Attachment E

Outstanding Responses to the City of Sydney issues raised in response to the exhibition of the redevelopment of the IMAX Theatre and surrounding public domain (SSD 7388)

**4** PODIUM L03 LEASE LINE RELATIONSHIP  
1:500

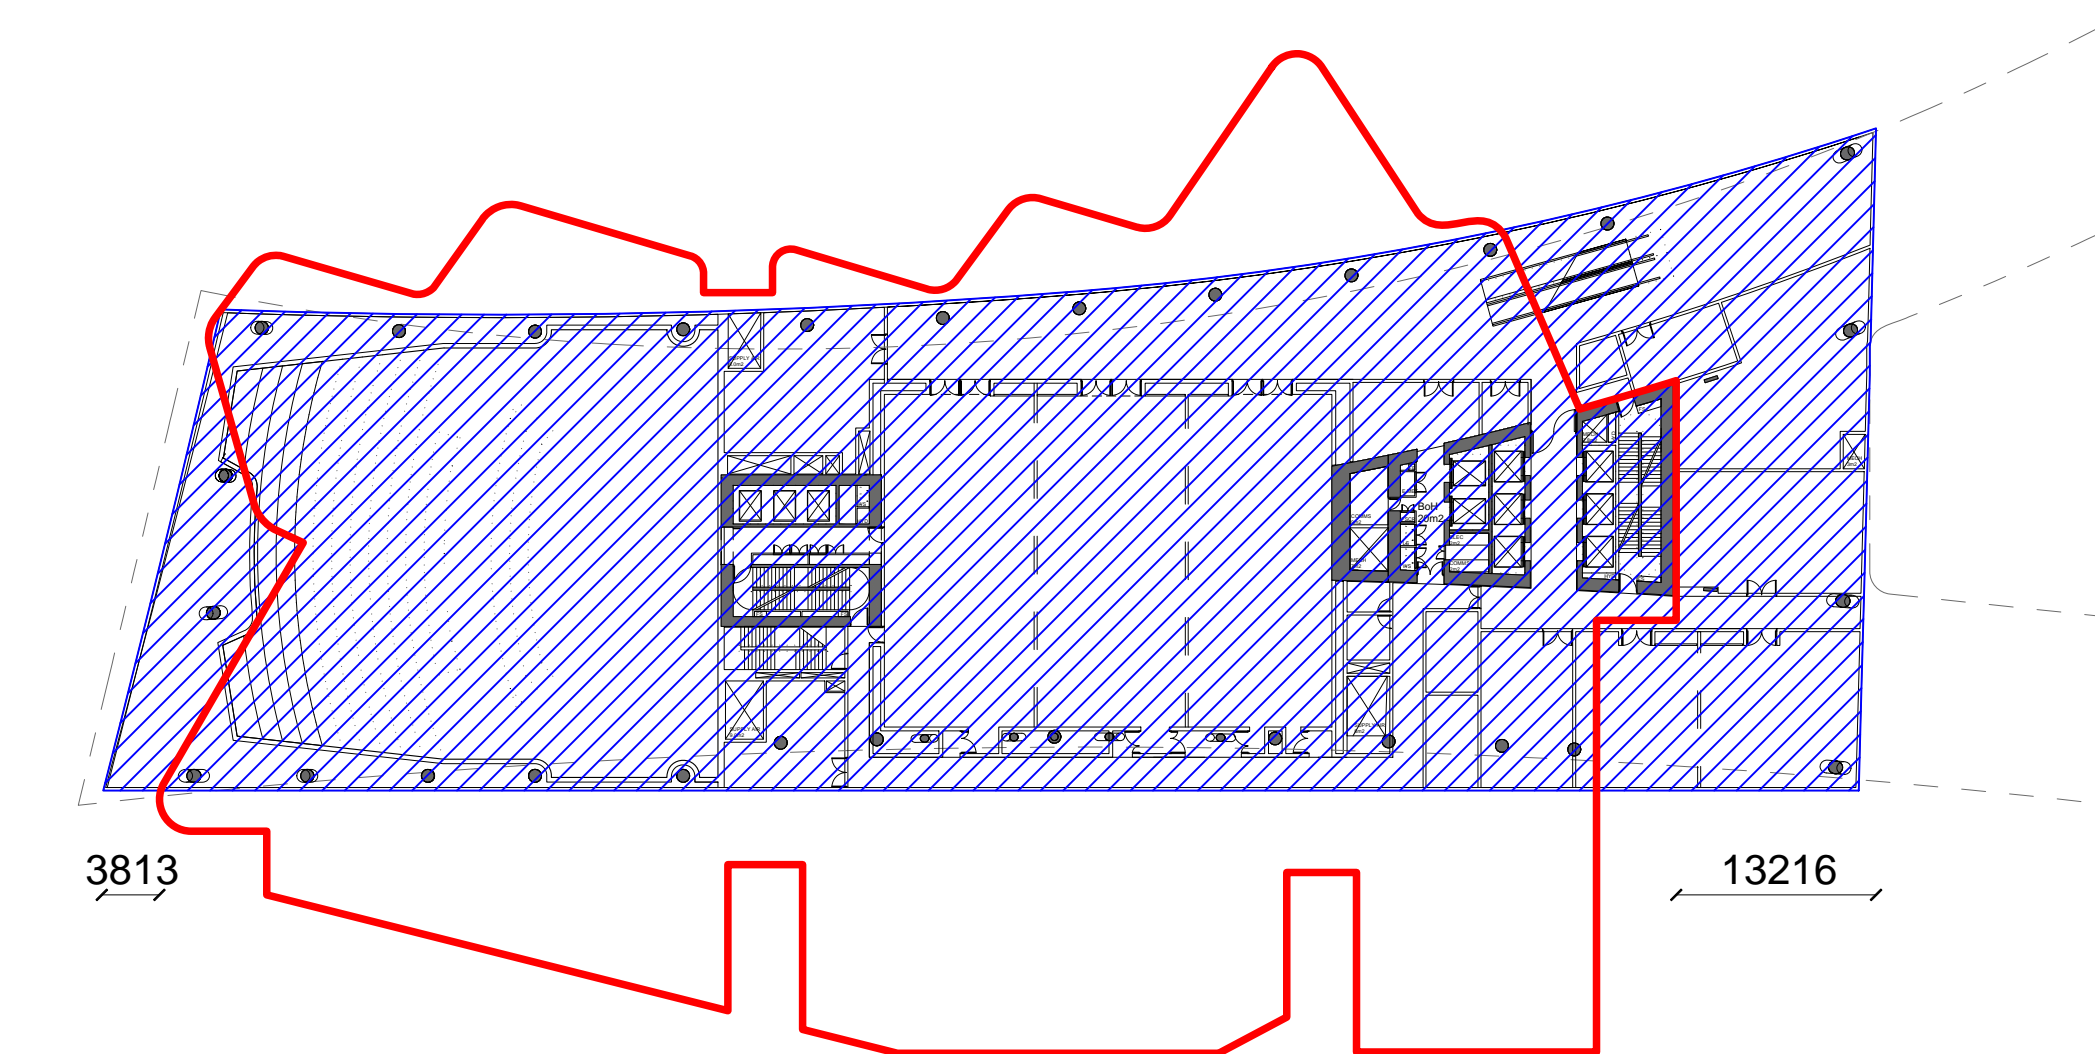
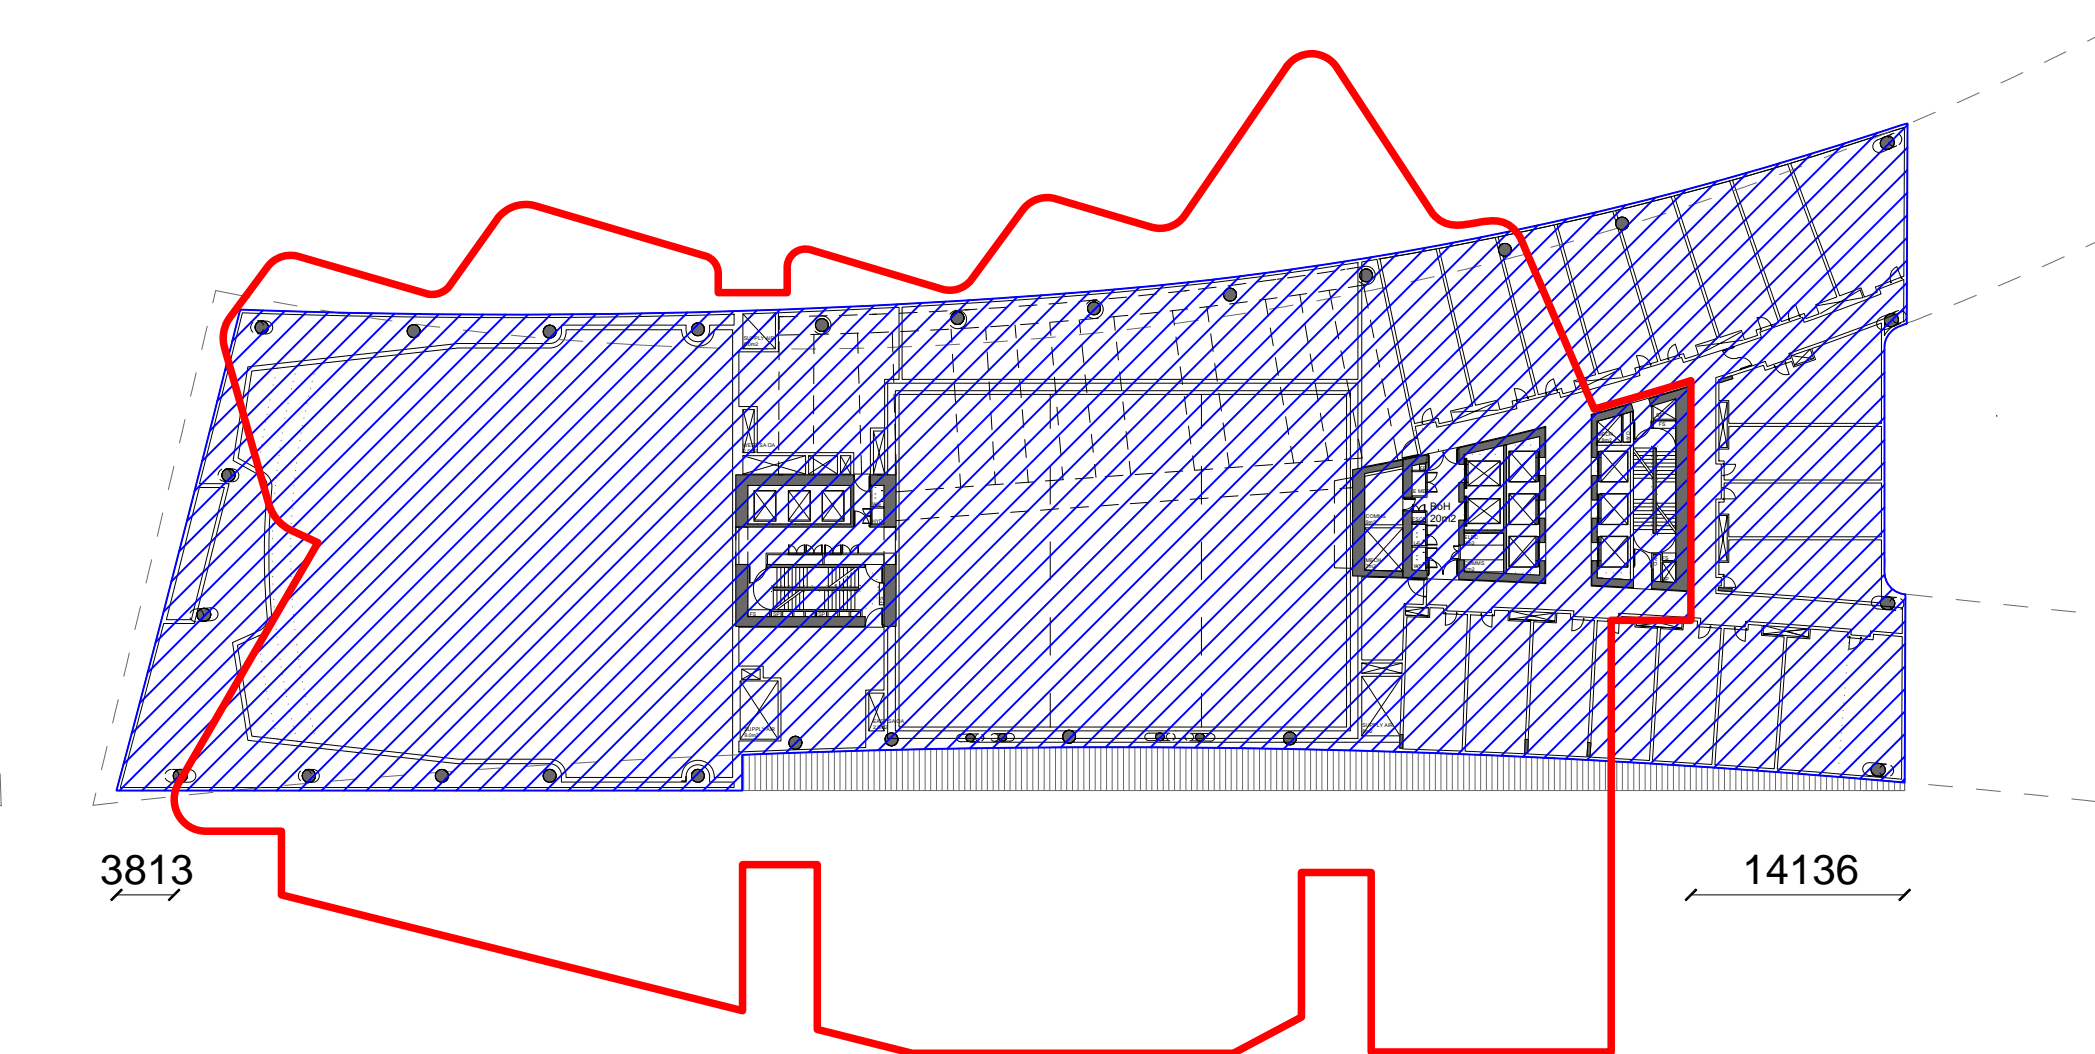
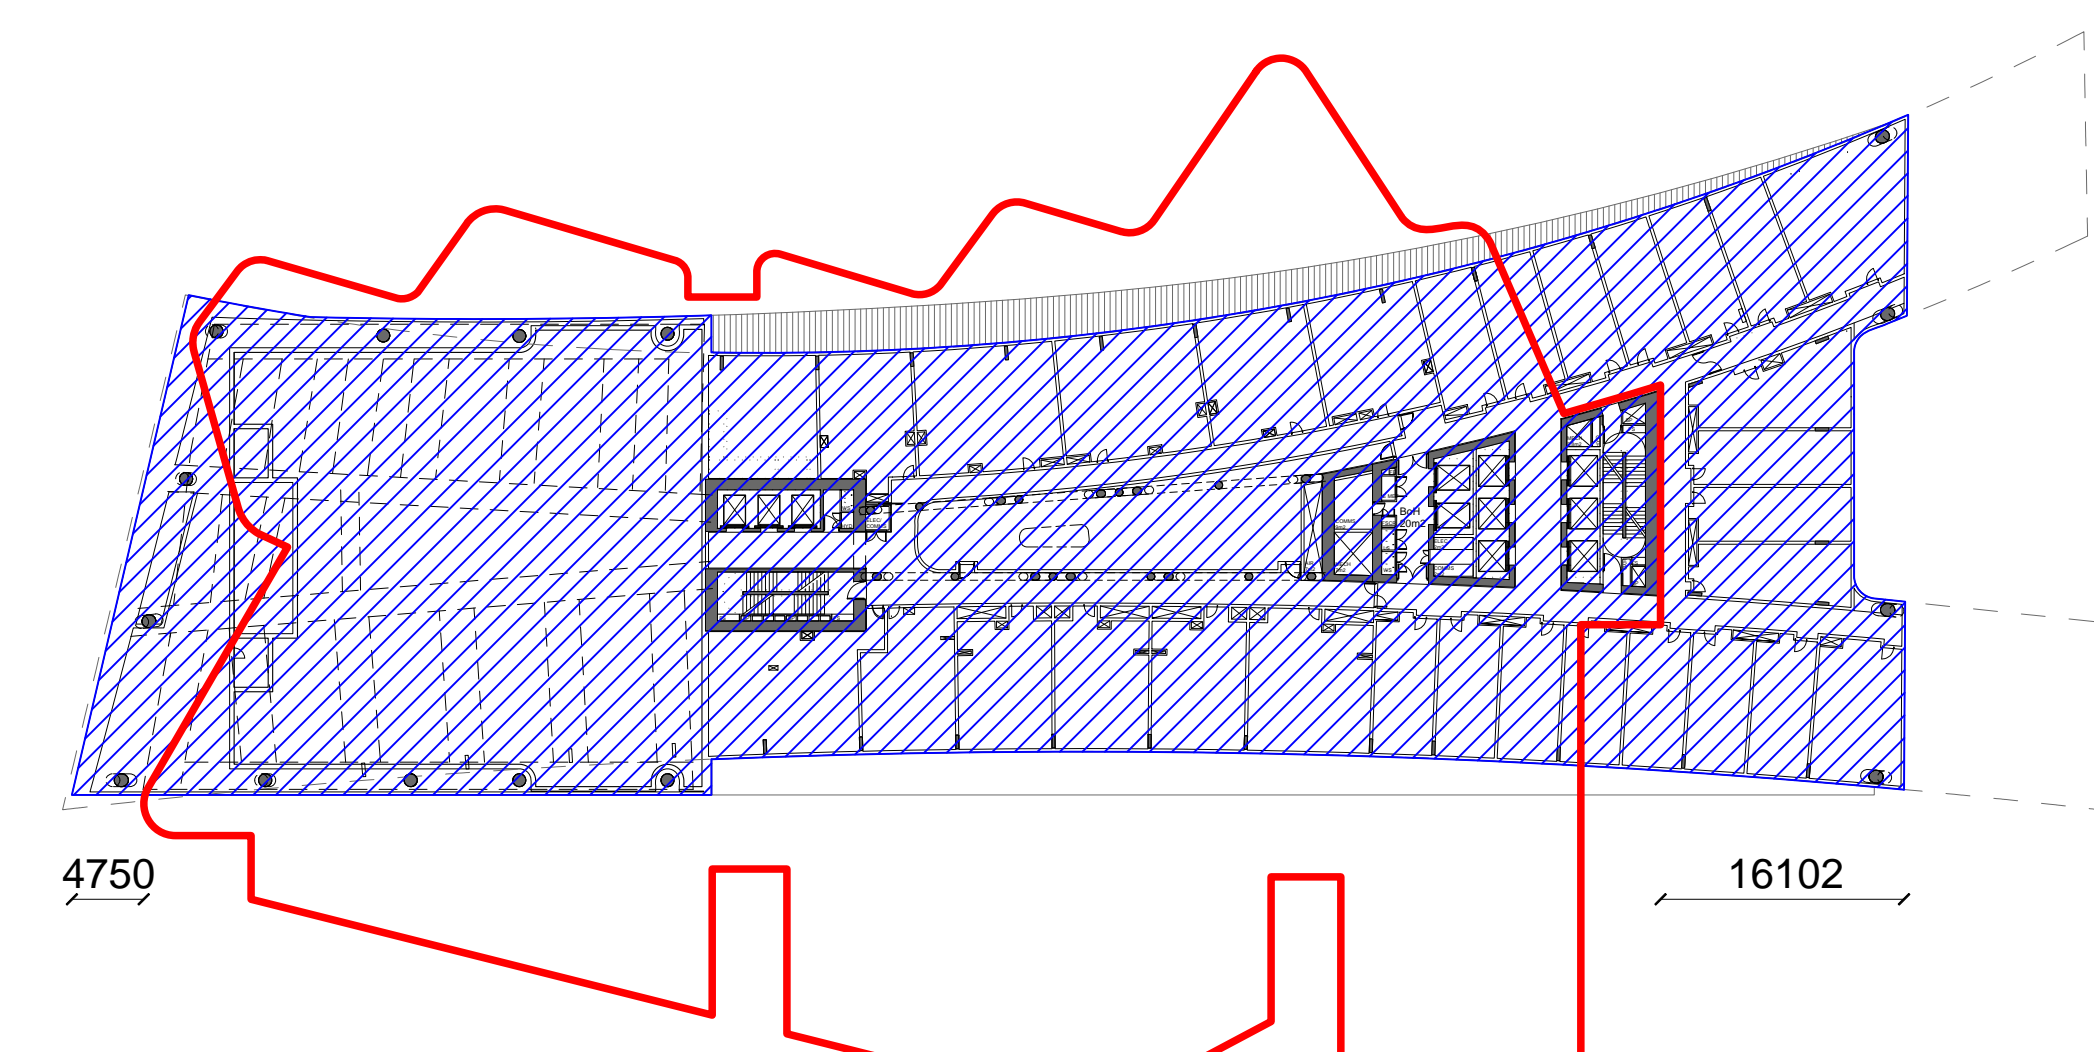
12	The proposal will result in a significant encroachment of the building into the public domain to the north and west of the building, beyond what is currently experienced. This concern was raised in the City's submission to SSD 5397 and is maintained for the current proposal.	The foot print of the building and it's impact on the public domain is very similar to that of the approved commercial scheme proposal.		As per original response.
17	Concerns are raised regarding pedestrian safety and conflict between pedestrians and vehicles crossing the vehicle entry point and around the porte cochere area. No information is provided as to how pedestrian safety will be managed. The design should include a continuous footpath across the driveway crossover to emphasise pedestrian priority and improve awareness of pedestrians and thus safety. Driveway crossing widths should narrowed as much as possible (preferably to 6m or less).	A clear pedestrian path has been provided along the eastern boundary which will not cross the porte cochere at any point;. The only point where pedestrians cross a vehicular path is located at the entrance of the loading bay/carpark. This will be clearly indicated and will not exceed 6 metres in width. - Refer to Attachment #17. The directness of the pedestrian route is largely unaffected by the development and, given the low share of pedestrian traffic accessing Cockle Bay and Darling Harbour, the development could not be expected to have a detrimental effect on the surrounding pedestrian network.	Attachment #17	The core issue of pedestrian amenity has not been addressed. The analysis provided merely examines if the pedestrian space can accommodate the pedestrian volumes in a flow rate which is acceptable. If pedestrian footpaths are reduced while accommodating increased pedestrian traffic, this will result in reduced pedestrian amenity. Further, the analysis does not look at the other issues which make up amenity (ie. directness, line of sight, lighting, use of the space for queuing /pick-up and drop- off, conflict with heavy vehicles, valet staff). Pedestrian priority should be provided across the vehicle entry to the loading dock including continuous footpath treatment. The proposed development is likely to have a detrimental effect on the surrounding pedestrian network.
